DRB Application No.: 08DRB-70240 Project # 1001656
 Project Name: Double Eagle II Airport & Adjacent Lands
 Agent: Molzine Corbin & Assoc. Phone No. _____

DEVELOPMENT REVIEW BOARD – SPEED MEMO

DRB CASE NO: 1001656

SITE PLAN FOR BUILDING PERMIT

TRAFFIC CIRCULATION LAYOUT (SITE PLAN)

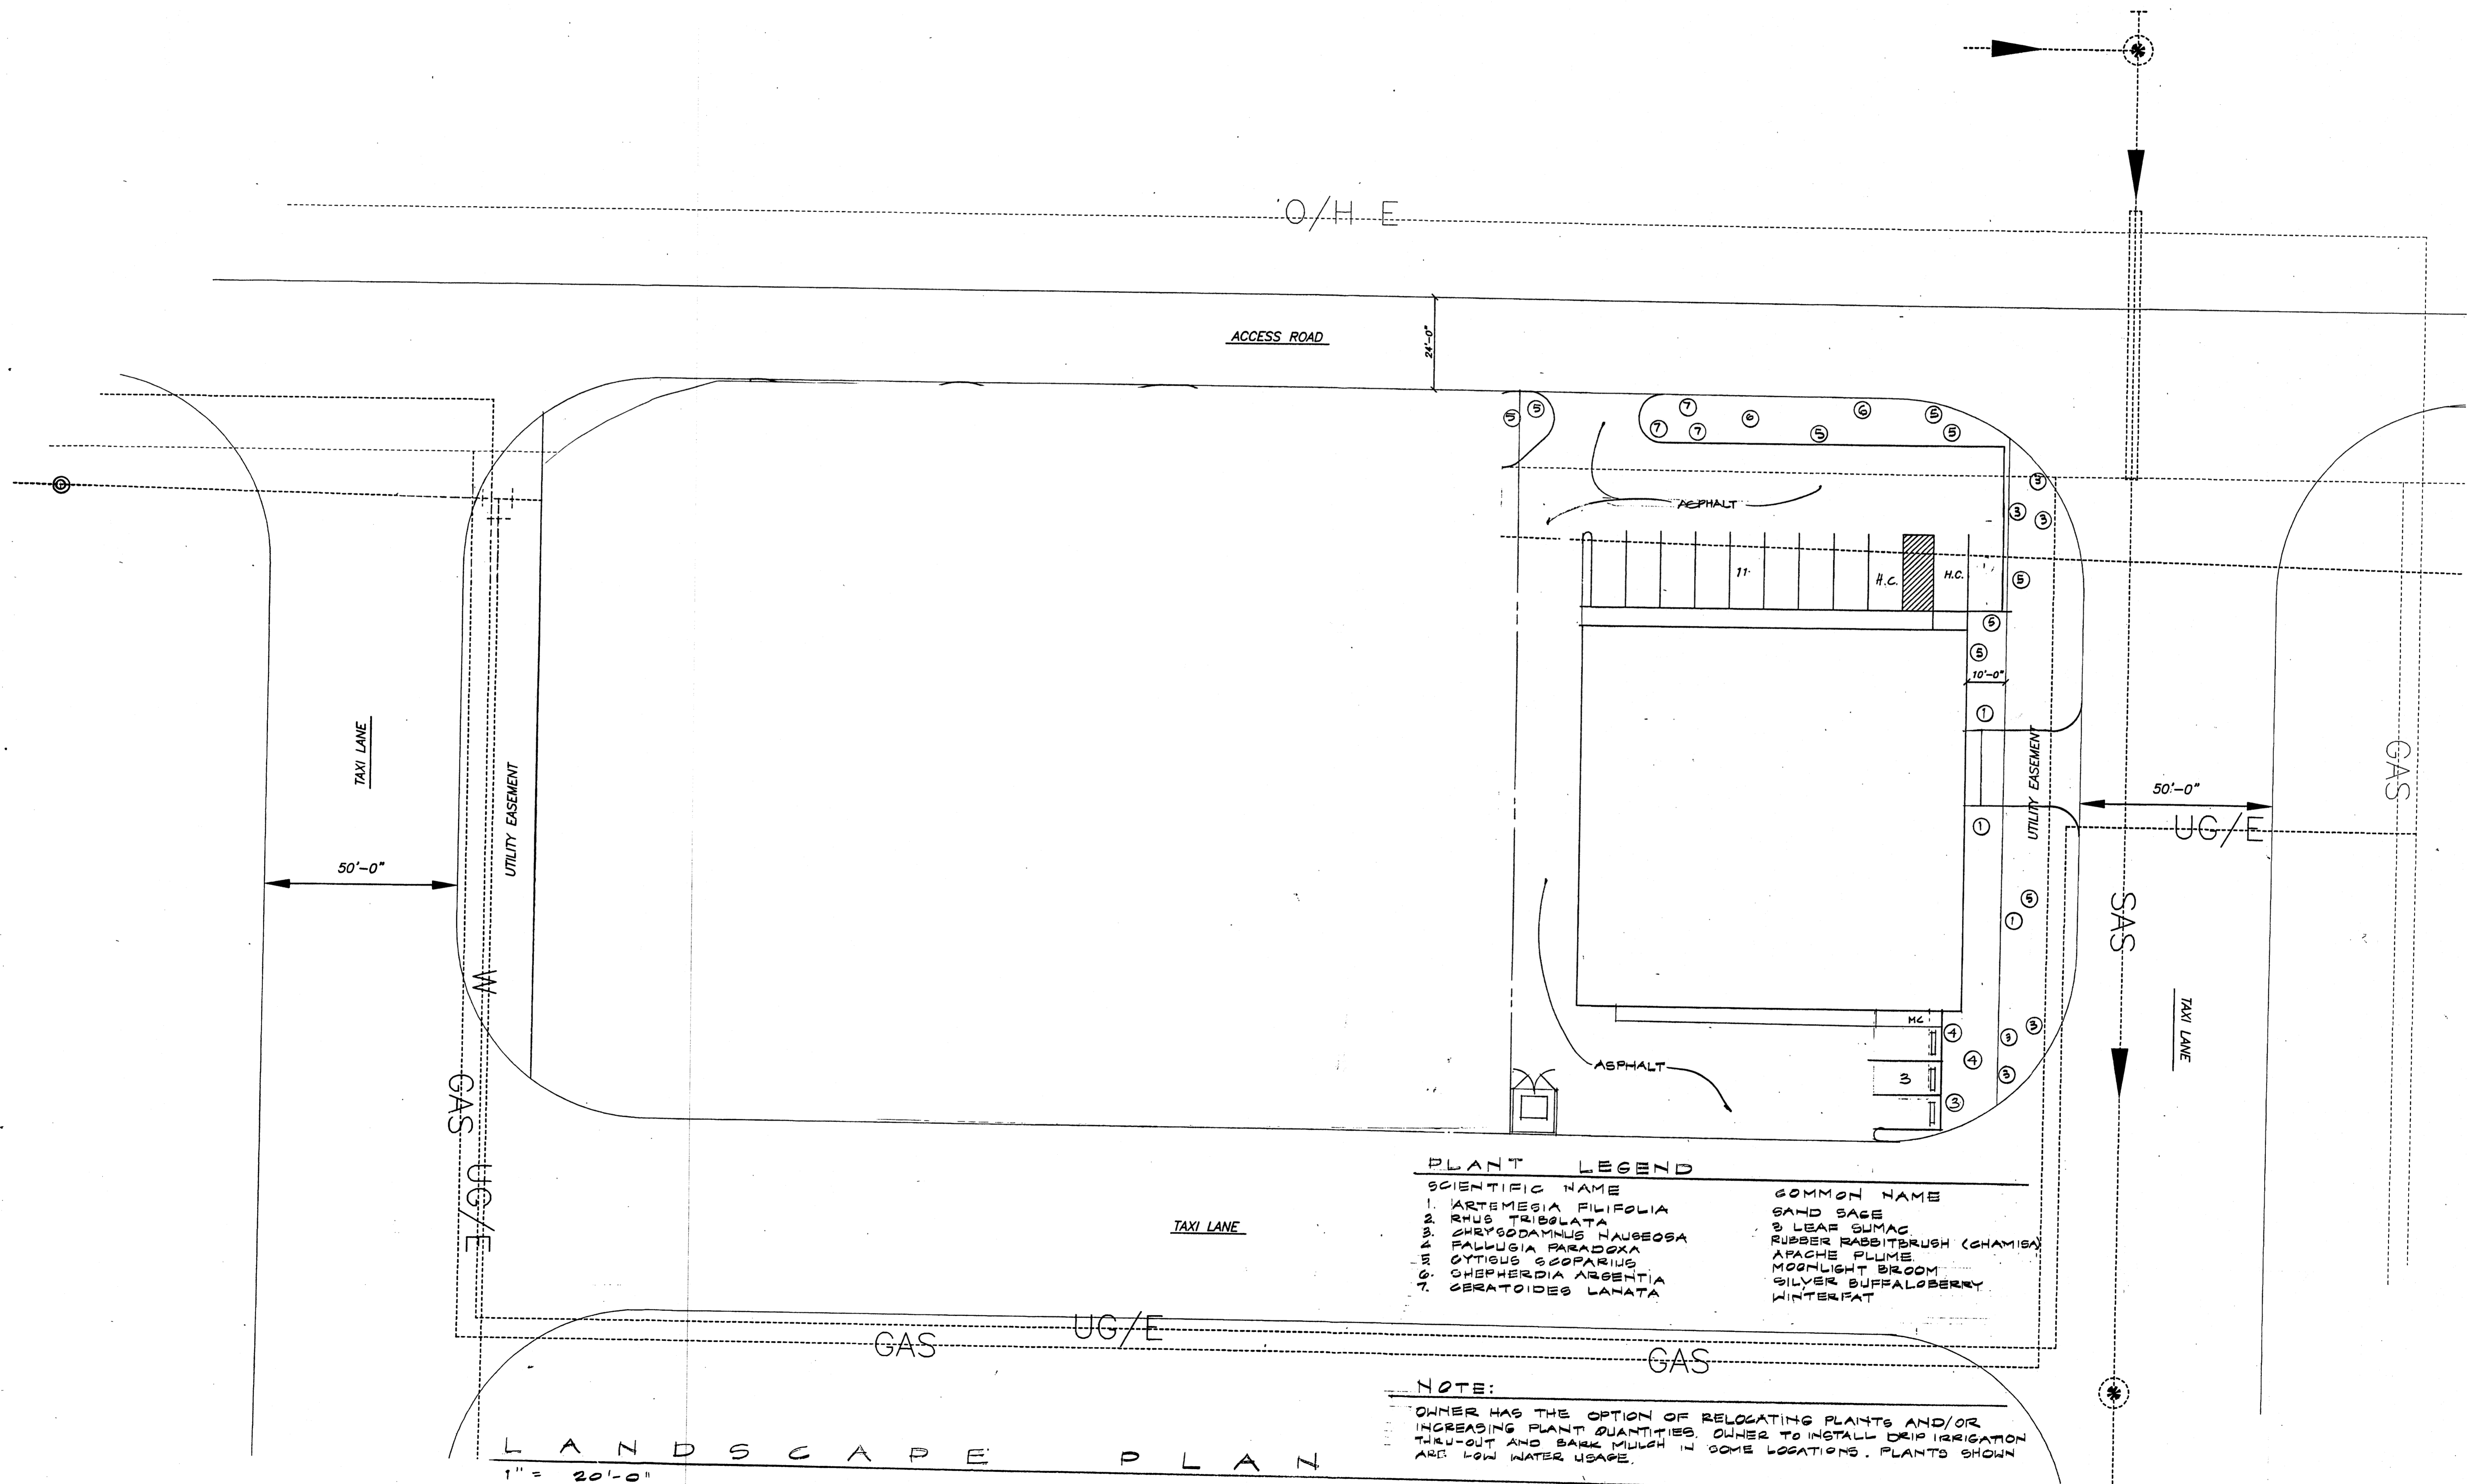
Provide an exhibit showing the location of sidewalk and defining the distance from face of curb to the property line.

The concrete stoops interfere with two directional traffic flow. → *Call out RUNS IN*

- A 5-foot keyway is required for all dead end parking stalls.

- Call out the aisle width at the proposed trash enclosure.
